**City of Sydney**

29 October 2010

**Sydney Fish Markets 56-60 Pyrmont Bridge Road, Pyrmont**

I refer to your request for comments on the current Part 3A Major Project application for the redevelopment of the Sydney Fish Markets (SFM) site.

CONCEPT PLAN

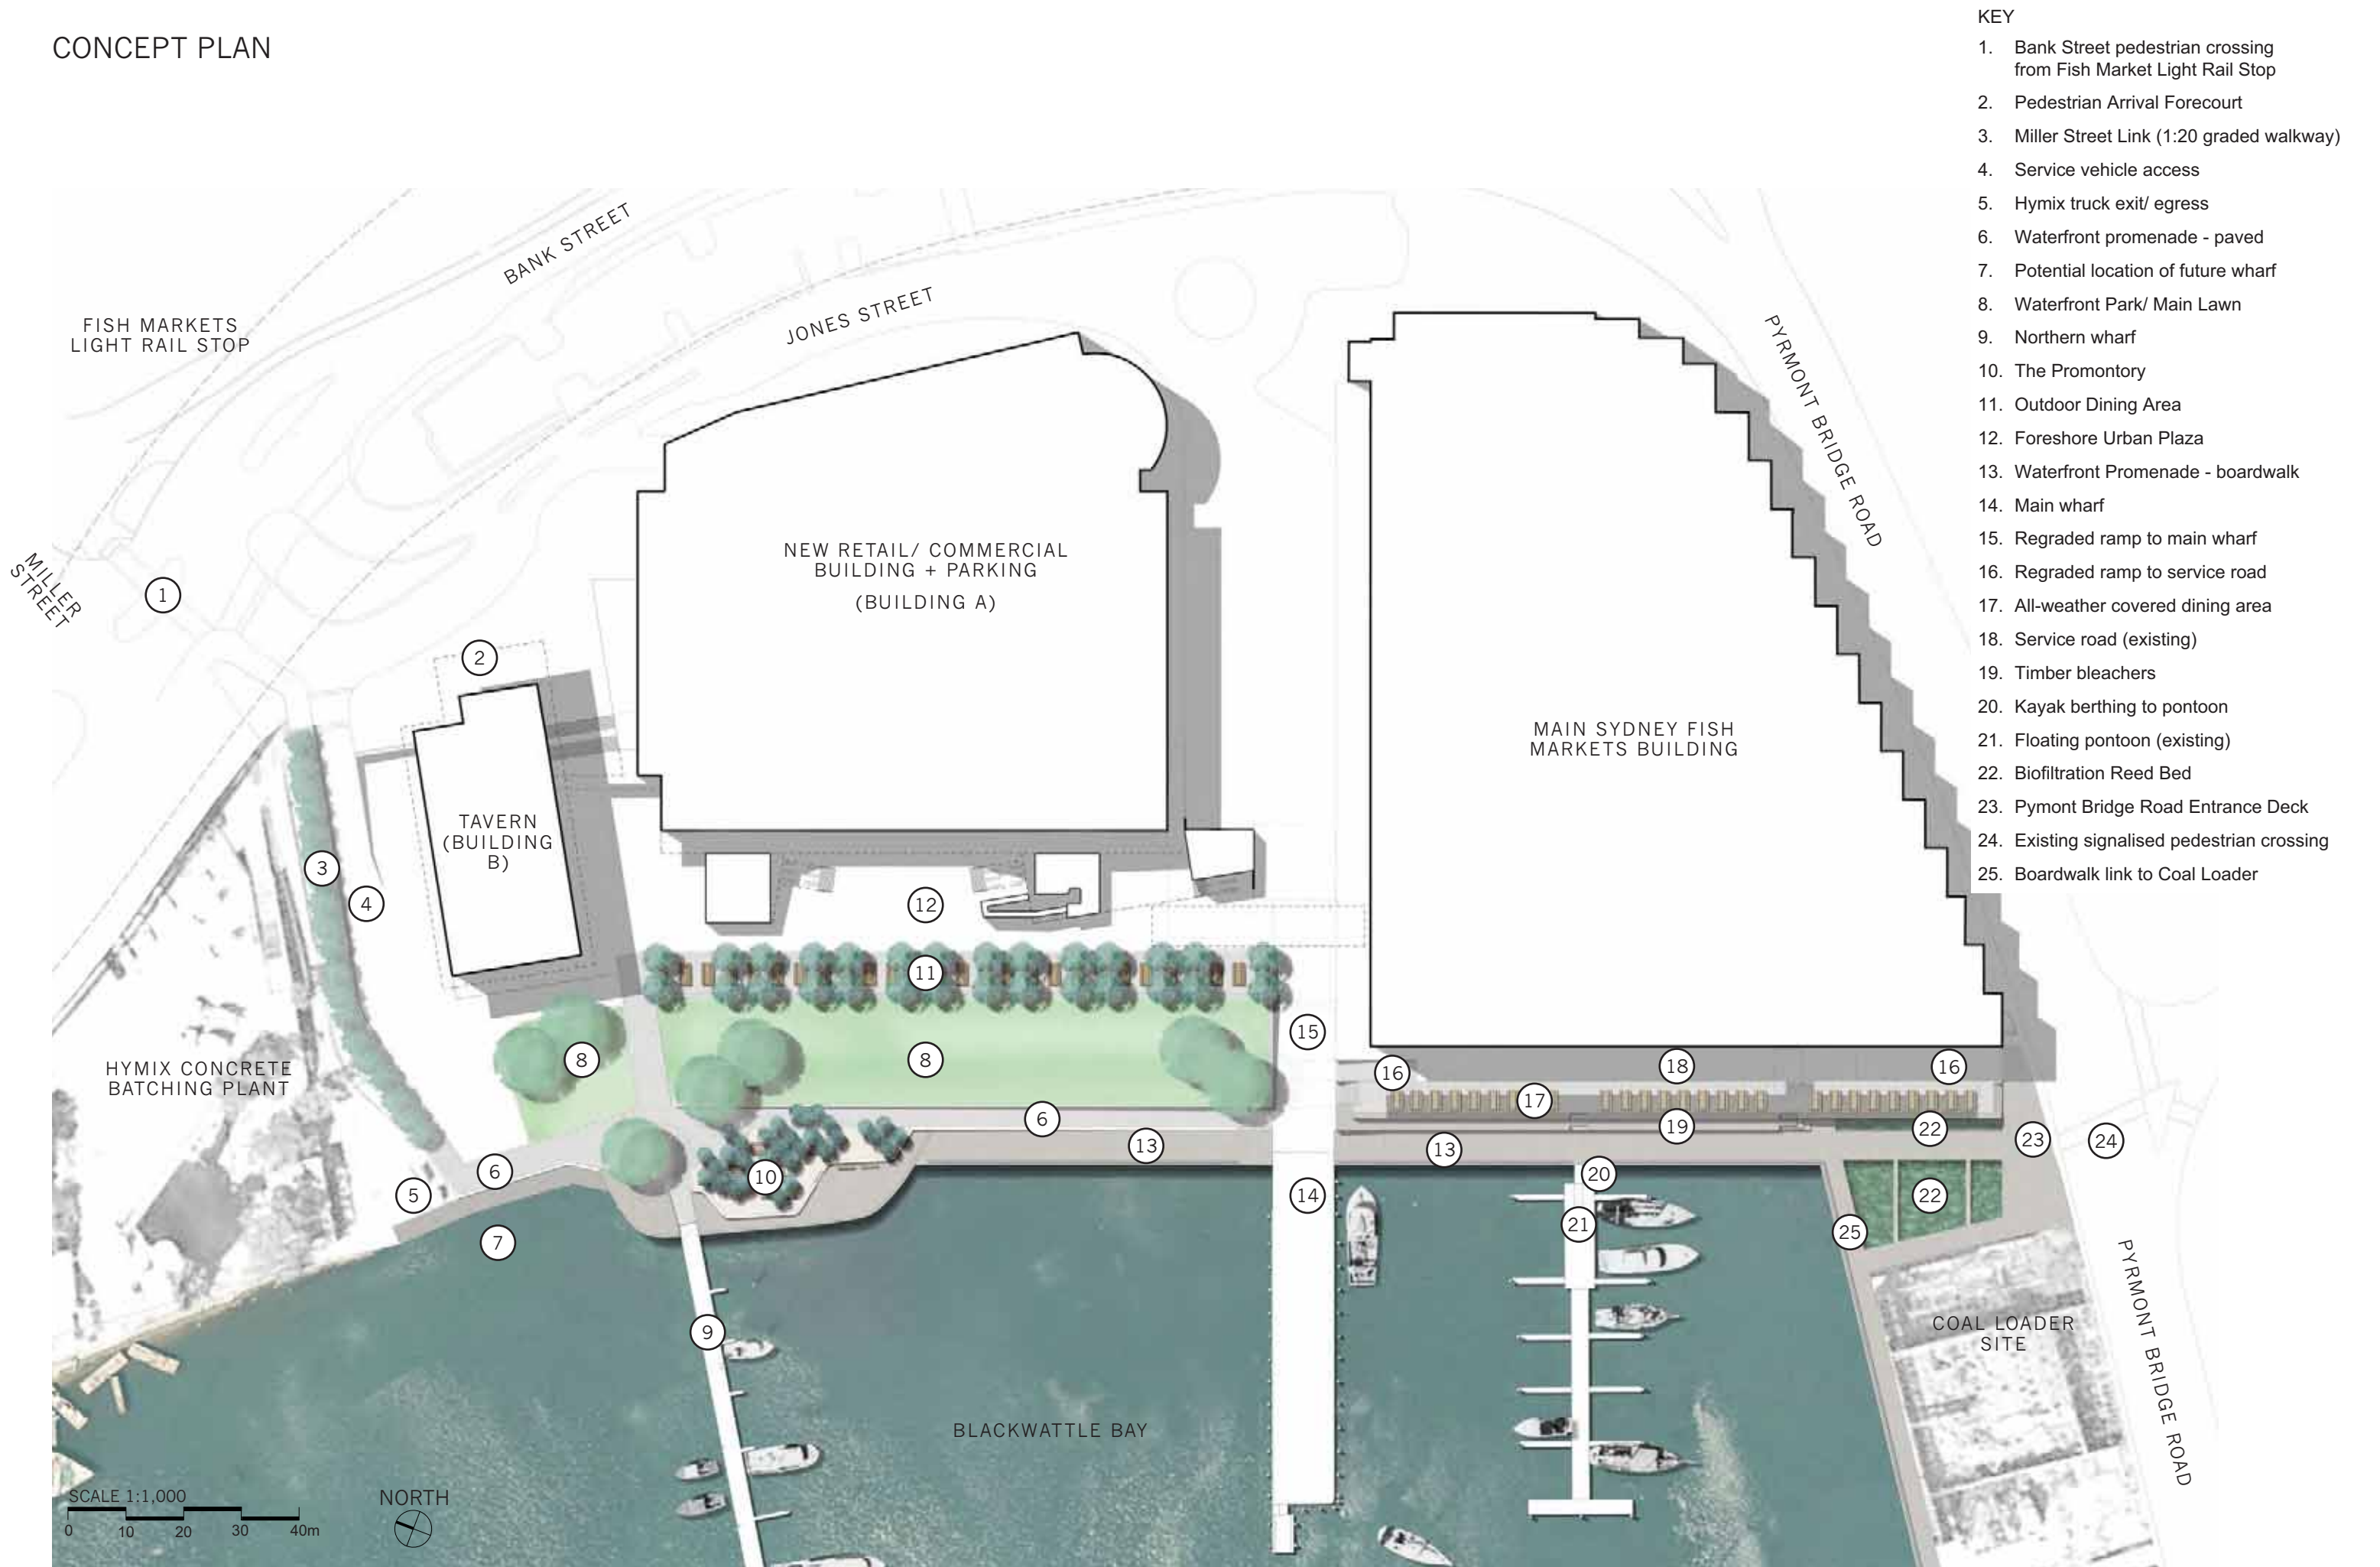
- A large number of trees are proposed to be removed along the site boundary adjacent to the Western Distributor. Therefore, Building A should be setback a minimum of three (3) metres to allow for replacement tree planting to replace the loss of tree coverage. Palms would be suitable.

- Tree numbered 23 is proposed for removal, however, it is recommended that it be retained. It is a mature and healthy tree which already provides screening of the site from the Western Distributor. It is noted the applicant's Arborist identifies this tree as the best specimen on site and therefore the design should be modified to allow its retention. A minimum setback is required of 3 metres. The plans must be amended to provide these setbacks.

- Trees numbered 26 and 27 are proposed for removal; however, it is recommended that these trees be retained. The two trees are large and healthy trees providing significant amenity to the site. A minimum setback of 8 metres is required to adequately protect the trees. The plans must be amended to provide these setbacks and any ground treatments within Tree Protection Zone should be above existing grade.

CONCEPT PLAN - ILLUSTRATIVE SECTION-ELEVATION D-D'

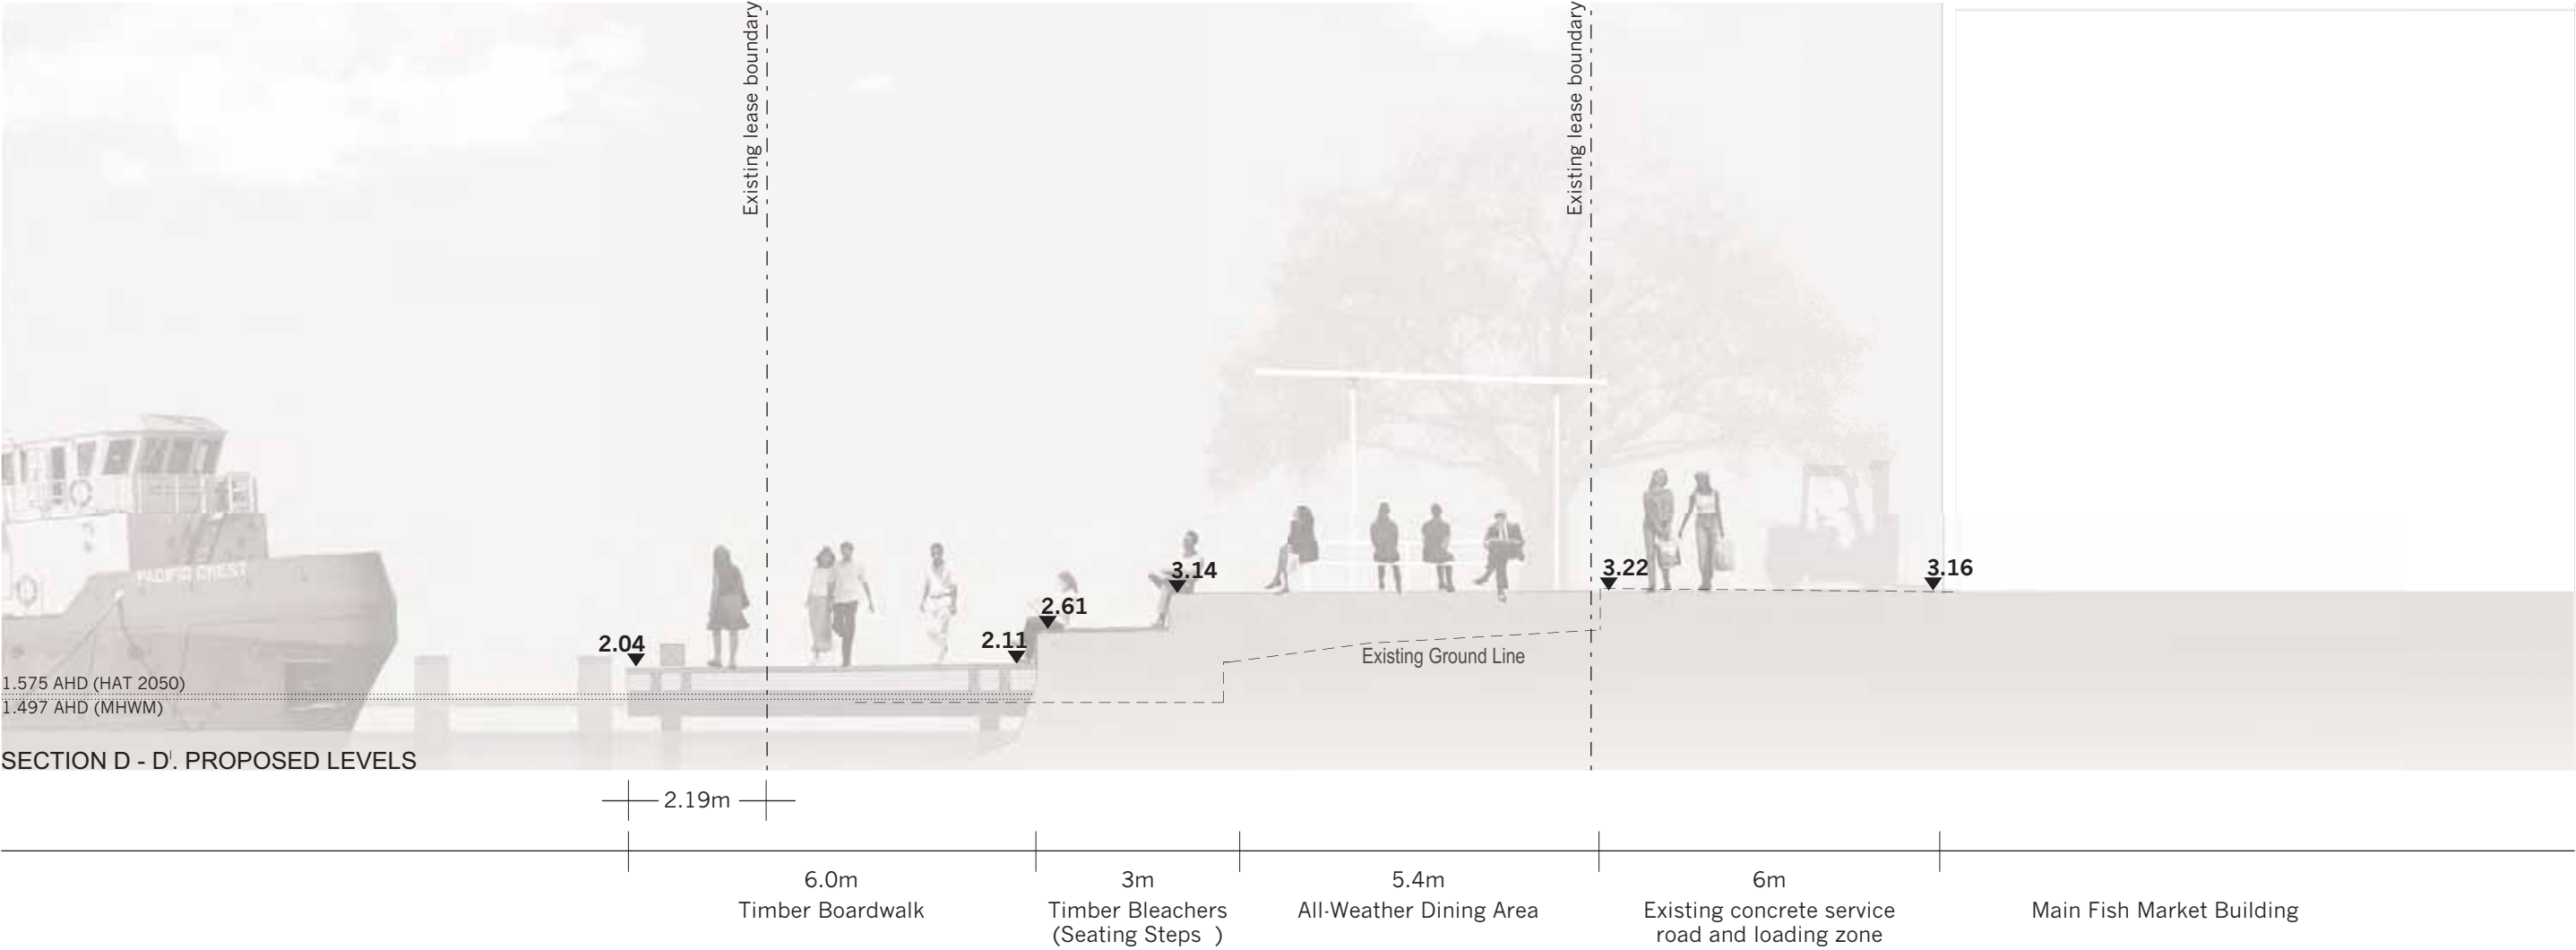
- The 6m wide timber boardwalk and 3.5m wide paved promenade is generally acceptable, although it is noted that at the southern end it is proposed to be used for shared circulation and greater consideration should be given to resolving conflicts between cyclists and pedestrians crossings at key access points.
- If the public foreshore area is to be dedicated to the City, then City standards for design must be adhered to.
- Information as to maintenance, dedication of land, register of easement on title or other arrangements will need to be submitted to The City for approval.
